Principal Areas of Disagreement Summary Statement (PADSS) from Surrey County Council - Version Number: Three Submitted at: Deadline Nine - 21st August 2024

Appendix A – NRP Temporary Compounds and Construction Vehicle (HGV) Access Routes

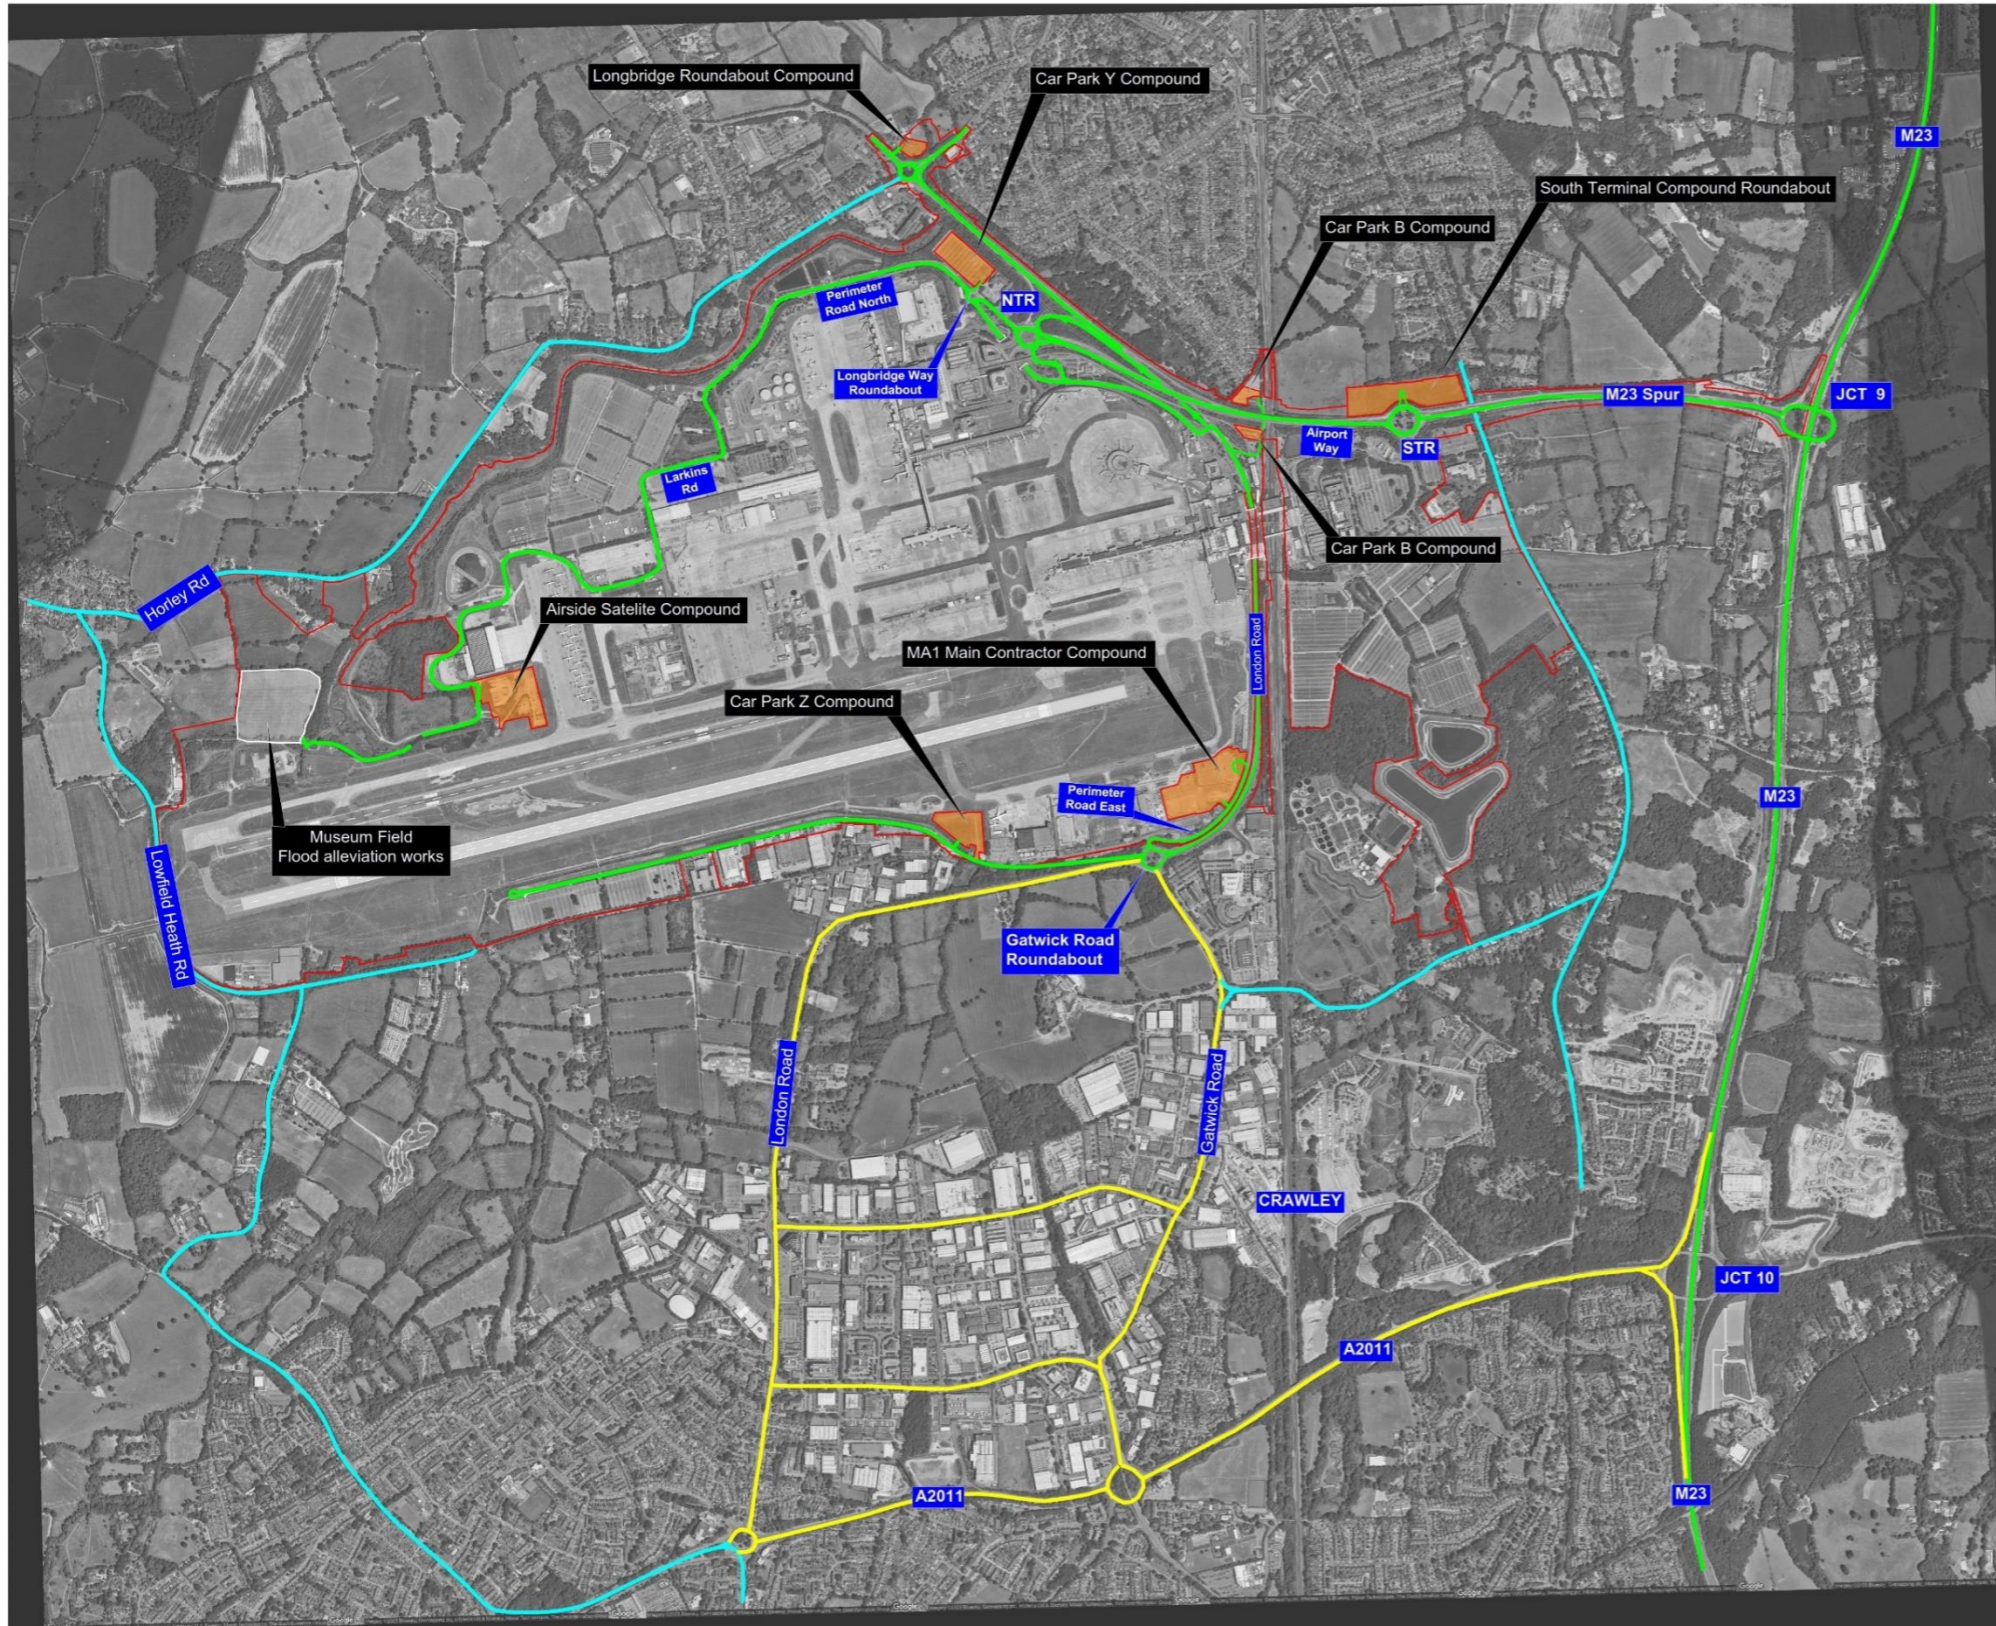
17	Securing mitigation	SCC is concerned that separate entrances to the South Terminal compound are proposed for HGVs (from the roundabout) and private vehicles (from Balcombe Road). This implies that an extended journey on the local road network is required.	SCC wishes to see all access to the South Terminal compound from the South Terminal Roundabout. SCC remains concerned that the proposed Balcombe Road access is referenced in DCO documentation.	Not addressed
Noise				
18	Air noise - Threshold and scope of LOAELs and SOAELs	The ES only considers the Leq metric for LOAELs and SOAELs. In doing so it makes reference to national policy. The consideration only of Leq as a metric is too narrow as it does not represent all the effects of air noise and other	Inclusion of assessment for a wider range of criteria, including but not exclusively, awakenings, N above contours	Not addressed
